One Earth Solar Farm

**Draft Statement of Common Ground with Newark and
Sherwood District Council**

EN010159/APP/8.6.1

August 2025

Drawing Number:  
EN010159/APP/6.20/10.1

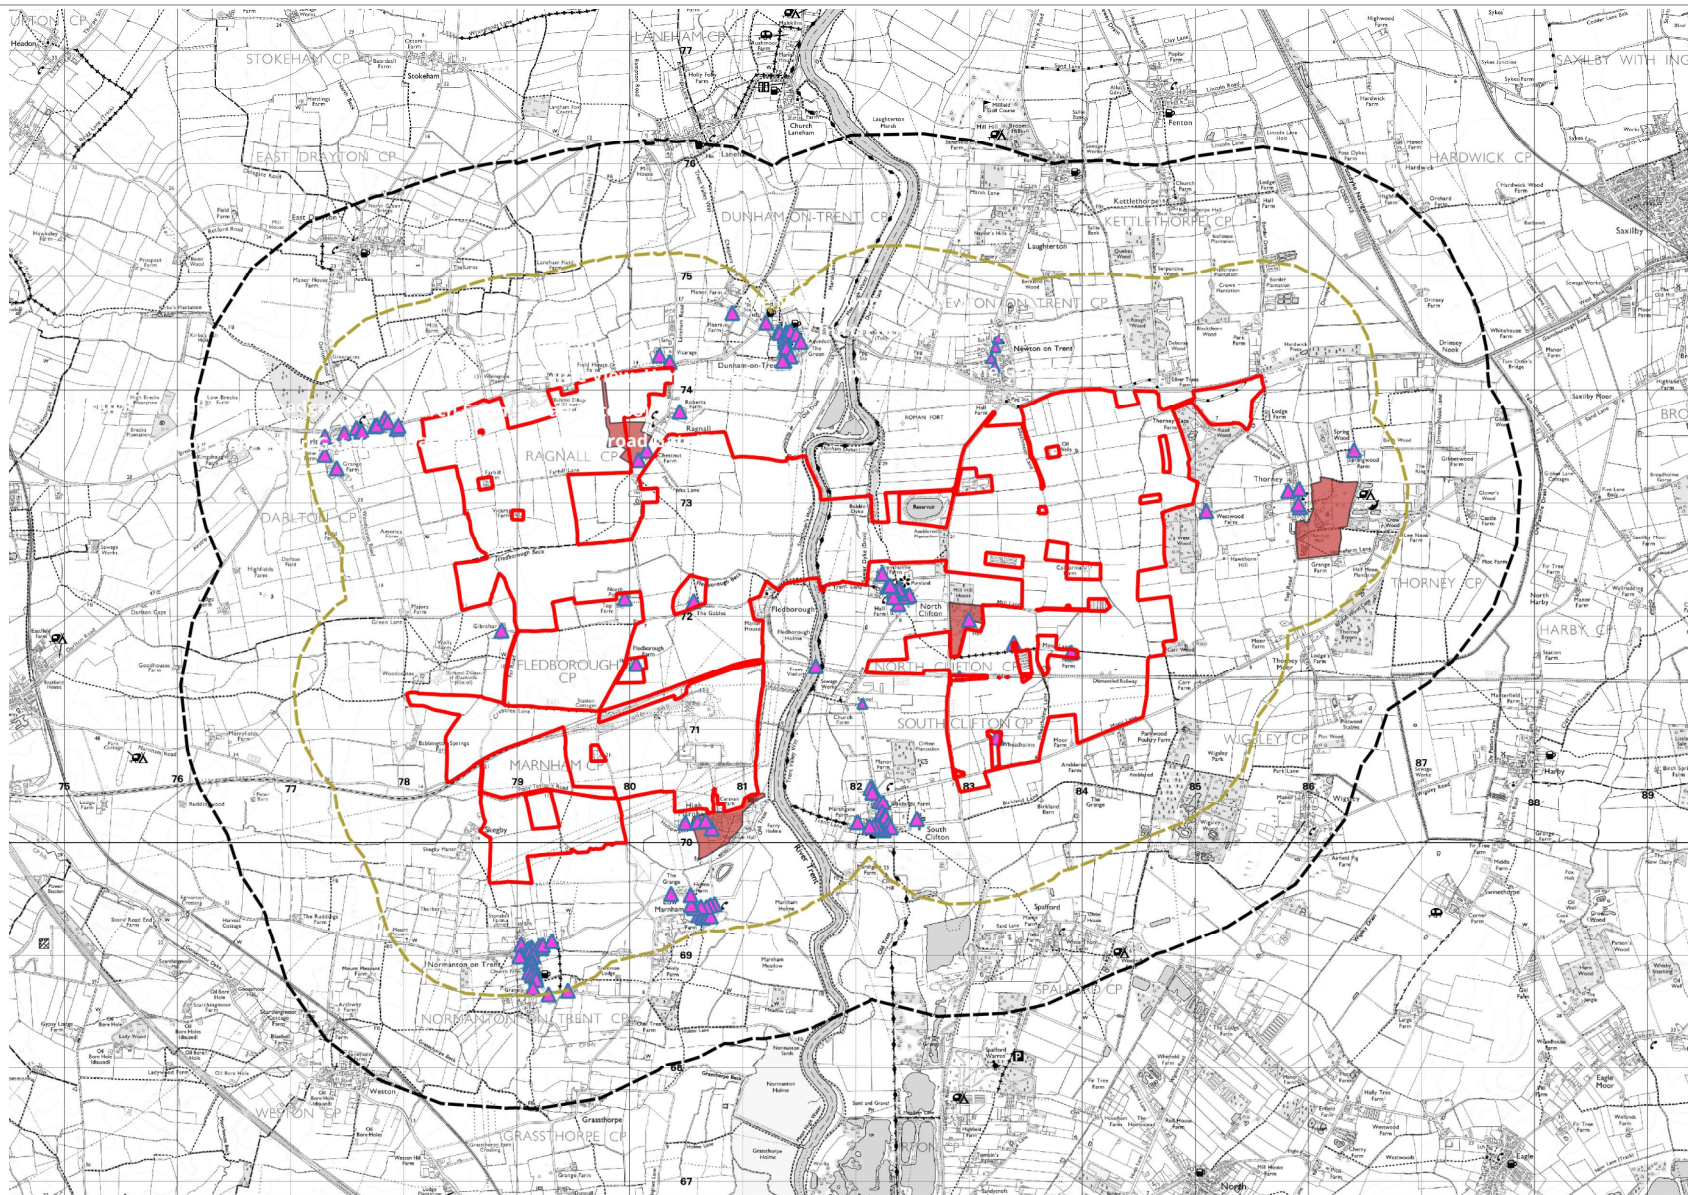
Further detail can be found in the Applicant's Response to Relevant Representations [EN010159/APP/9.3]	
02-08	Firs Farmhouse (Grade II)	Small strip of the solar farm seems encroach towards the heritage asset	Figure 10.1 [APP-055] of ES Chapter 10 [APP-039] confirms that the Order Limits stand at c.930m to the west of this asset. There is no stretch of the Order Limits which stand within the vicinity of the asset and no harm will arise. Further detail can be found in the Applicant's Response to Relevant Representations [EN010159/APP/9.3]	Agreed
02-09	Hall Farmhouse (North Clifton. Grade II, NHLE: 1302529)	There may be possible views from this heritage asset.	As illustrated within Viewpoint 25a (Figure 11.13.7 ^a [APP-068]) and assessed at paragraph 10.6.96 of ES Chapter 10 (ref. APP-039), the Order Limits would stand distant from the asset and hold no intervisibility	Under Discussion
02-10	Trent Lane Farmhouse (North Clifton. Grade II, NHLE: 1369937)	There will be views in nearby field. Recommended mitigation suggest increased hedging to the south of the heritage asset.	The Order Limits would stand at distance from the asset (over 280m to the north), would not backdrop views of this asset from the Viaduct, and would hold no adverse effect on the appreciation of the asset as an agriculture farmhouse.	Under Discussion

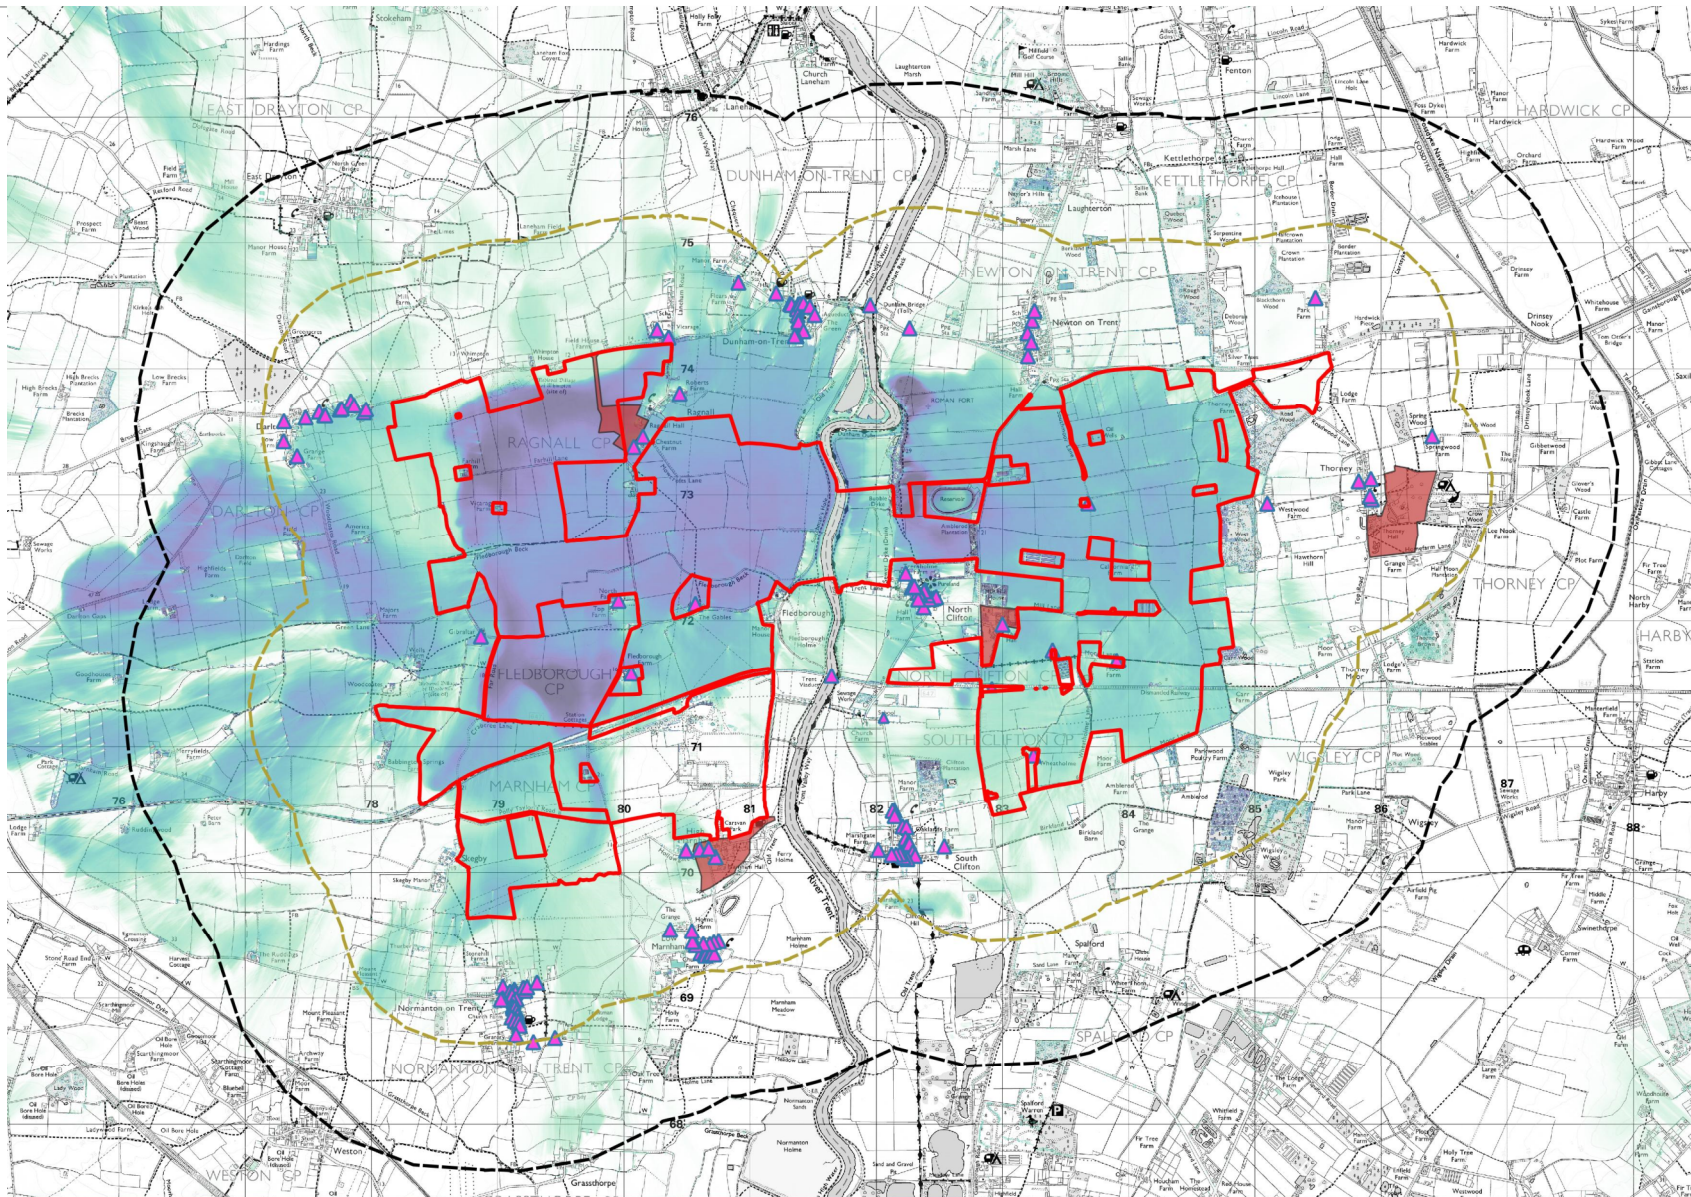
02-04	Perceived impact to Church of St George the Martyr and Church of St Helen	Further consideration required on setting of both assets and further mitigation required – specifically for the impact on Church of St Georgie the Martyr, and Church of St Helen.	<u>Church of St George the Martyr</u> Effects of the Proposed Development on St George the Martyr are located within paragraphs 4.136 – 4.139, page 66 of Technical Appendix 10.3 [APP-128] and paragraphs 10.9.9 and 10.6.98.100 of ES Chapter 10 [APP-039]. <u>St Helen Church</u> This asset has been assessed in ES Chapter 10 (ref. APP-039) at paragraphs 10.6.7 and	Under Discussion

02-06	Lychgate at Church of St George	“Impact of proposal This listing would not be as impacted as the Church of St George due to its location, but it still forms part of the wider setting.... Recommended Mitigation None would be required for this heritage asset.”	The Zone of Theoretical visibility (Figure 10.3 [APP-055]) confirms no intervisibility of the Proposed Development. There would be no effect on the appreciation of the church, churchyard and lychgate Therefore, this asset would not change the assessed effects (or lack thereof) on the Church of St George the Martyr (Grade II*). Further detail can be found in the Applicant’s Response to Relevant Representations [EN010159/APP/9.3]	Under Discussion
02-07	Fledborough Viaduct	The impact of solar panels either side would be detrimental to the wider setting of the viaduct.	No solar arrays are to be located on either side of the viaduct as the land is not included within the Order Limits. It is unclear which northern small parcel is recommended for removal; to clarify the nearest Order Limit north of the Site is at c.660m. As noted within paragraphs 10.6.68 – 10.6.71 of ES Chapter 10 [APP-039], the industrial historic interest of the asset is not reliant on views of a particular character of the landscape to understand its value. The Proposed Development would hold a negligible neutral effect and result in no change to the contribution of the wider setting to asset’s value.	Agreed

02-13	Cottage at Thorney Hall (Thorney.	Suggestion to increase hedging to the south of the asset for mitigation.	Figure 10.3 [APP-055] confirms that there would be no intervisibility with the Order Limits. The Proposed Development would not affect the value (significance) of	Under Discussion

10.6.126, in paragraph 4.191 of the Technical Appendix [APP-128]. The Zone of Theoretical Visibility mapping [Figure 10.3 (APP-055)], the Proposed Development would hold no visibility. Further detail can be found in the Applicant's Response to Relevant Representations [EN010159/APP/9.3]	
02-05	Ruins of Old Church in Churchyard	Recommendation of further mitigation to protect any views.	This asset has been assessed in ES Chapter 10 (ref. APP-039) at paragraphs 10.6.7 and 10.6.126 and on page 85 of Appendix 10.2 (grouped with other assets in Thorney, as agreed with stakeholders – see Table 10.5 [APP-128]). The Zone of Theoretical Visibility, there would be no impact to the value (significance) of this asset, further mitigation is not required as no harm can feasibly exist which requires screening. Further detail can be found in the Applicant's Response to Relevant Representations [EN010159/APP/9.3]	Under Discussion

Grade II, NHLE: 1369961)		the asset and no further mitigation is required. Further detail can be found in the Applicant's Response to Relevant Representations [EN010159/APP/9.3]	
02-14	House at Thorney Hall. (Thorney. Grade II, NHLE: 1046017)	Suggestion to increase hedging to the south of the asset for mitigation.	Figure 10.3 [APP-055] confirms that there would be no intervisibility with the Order Limits. The Proposed Development would not affect the value (significance) of the asset and no further mitigation is required. Further detail can be found in the Applicant's Response to Relevant Representations [EN010159/APP/9.3]	Under Discussion
02-15	Summary of response	Request for further information on the impacts to the Church of St George the Martyr, and Fledborough Viaduct.	Further information provided to support the assessment that the Proposed Development would not be seen in views of St George the Martyr from the Viaduct. Confirmation of where the assets mentioned have been assessed within ES Chapter 10 [APP-039] and accompanying appendices has been provided to demonstrate that there would be no harmful effects to any of these assets and, as such, no further mitigation is required.	Under Discussion
